**Our ref:** AN/2023/134163/05-L01  
**Your ref:** EN010123  
**Date:** 28 November 2023

**Application by Ecotricity (Heck Fen Solar) Limited (“the Applicant”) under the Planning Act 2008 for the Heckington Fen Solar Park Development Consent Order on land at Six Hundreds Farm, Six Hundreds Drove, East Heckington, Sleaford, Lincolnshire**

Pursuant to Deadline 3, the Environment Agency notes that the Examining Authority invites comments on any submissions received at Deadline 2.

Figure 4.21 – Central Control Building

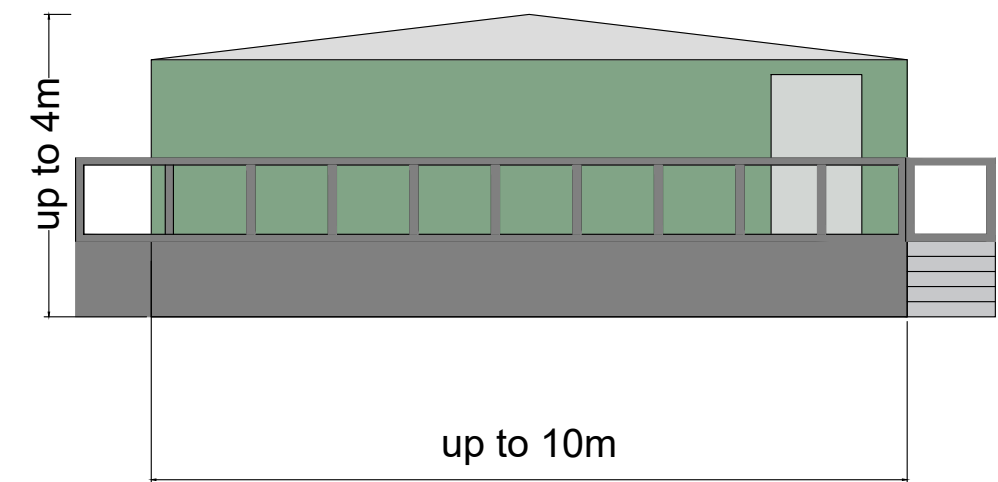
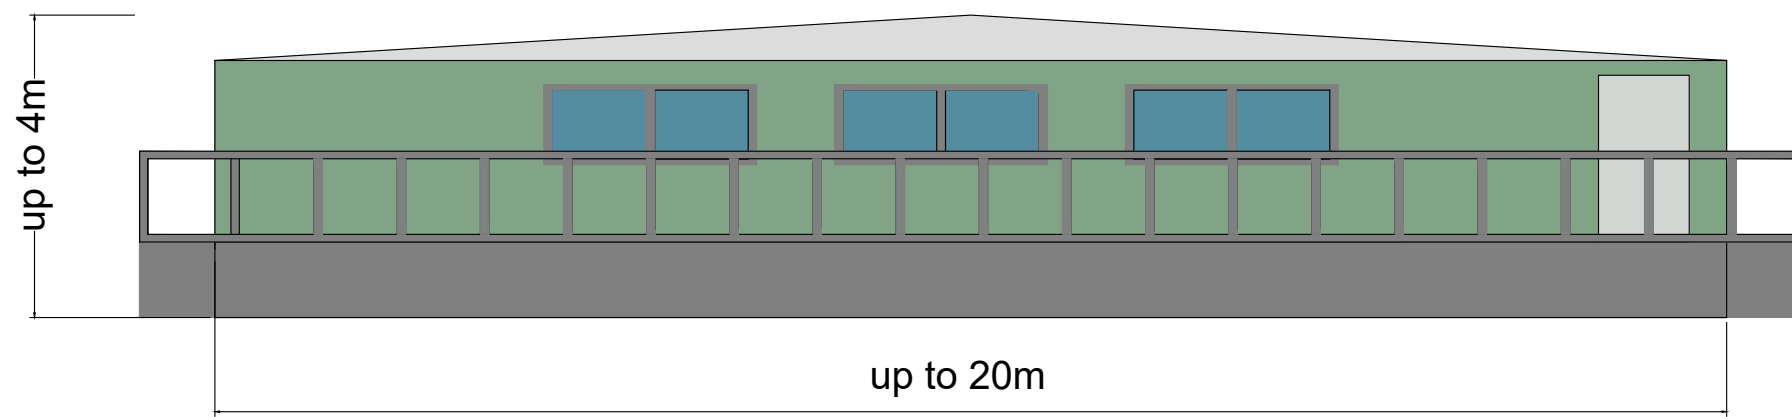
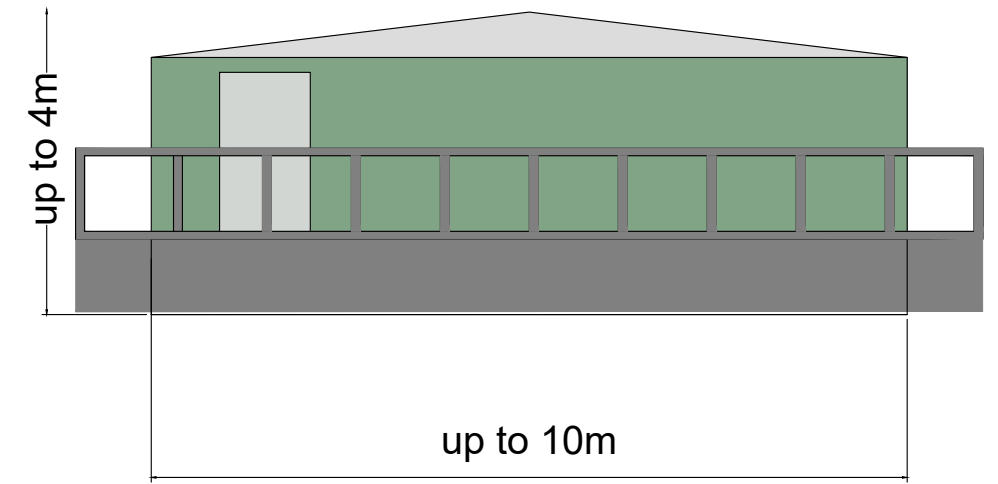
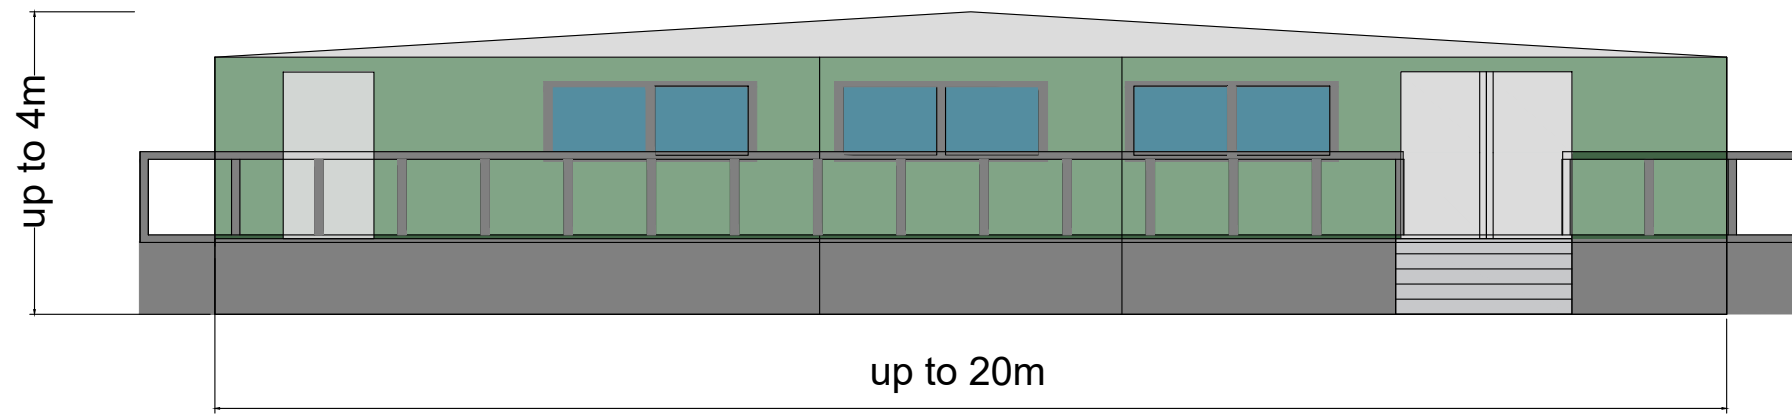
**Figure 4.21 (Central Control Building) [[REP2-044](#)] and Figure 4.22 (Substation Control Building) [[REP2-045](#)]**

We welcome the submission of Revision 2 of the above plans, which includes confirmation that the finished floor levels of both buildings will be at or above 2.25mAOD (above Ordnance Datum). This matter is now resolved.
